FULL

Reference:	H17-1026-23	Date of Decision:	18th January 2024
Applicant:	Mr G Giessler 5 Low Gate Surfleet Spalding Lincolnshire PE11 4AS		
Location:	5 Low Gate Surfleet Spalding		
Description:	Proposed open front store

Front Elevation

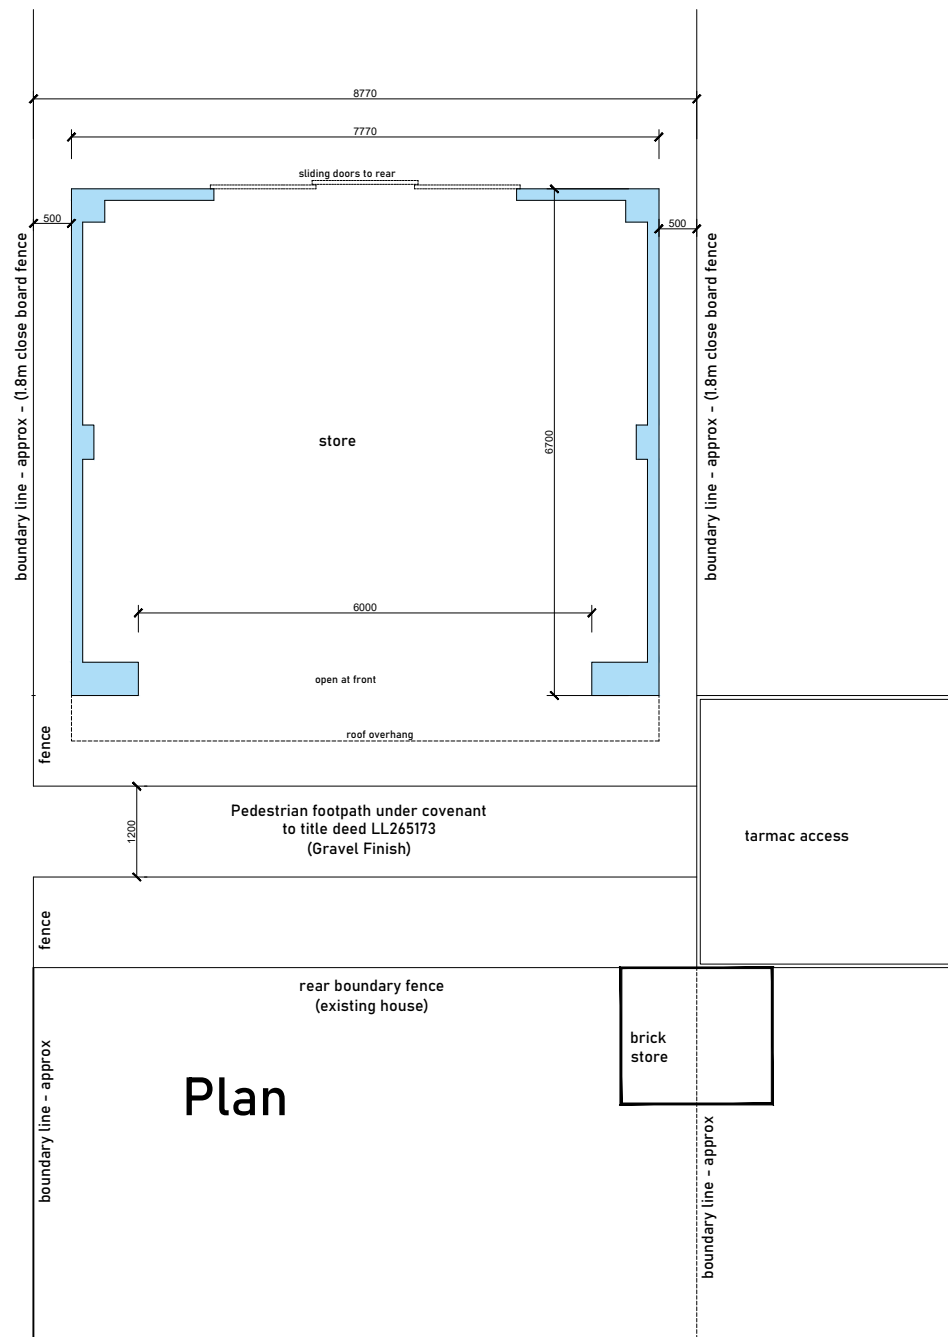
- 1 The proposal, by virtue of its significant scale, would represent an unduly dominant, obtrusive and alien feature within the locale. These visual impacts would be exacerbated by the existing significant outbuildings in the immediate area, creating a cumulative impact which severely intrudes upon the countryside and harms the character of the area. As such, it is considered that the proposal does not conform to the characteristics of good design outlined within the National Design Guidance, and therefore, fails to conform to Policies 2 and 3 of the South East Lincolnshire Local Plan, 2019 and Section 12 of the National Planning Policy Framework, December 2023. Policies 2 and 3 of the South East Lincolnshire Local Plan, 2019 further emphasise the need for new development to respect the distinctive scale and proportions of an area and that contradicting these characteristics would damage the character of the area.

- 2 The proposed use of concrete blocks would represent an incongruous material, at odds with the character of the area. Paragraph 57 of the National Design Guide requires the materials for all developments to be attractive and contribute to local distinctiveness. As there is no precedent for this material in the area, it is considered that the use of concrete would appear alien, harmful to the character of the area and in direct conflict with Paragraph 57.

- 3 The proposed outbuilding, by virtue of its height and siting, would overshadow the garden of 6 Low Gate. This would significantly reduce the sunlight reaching the garden and therefore would reduce the quality of life of the occupiers.
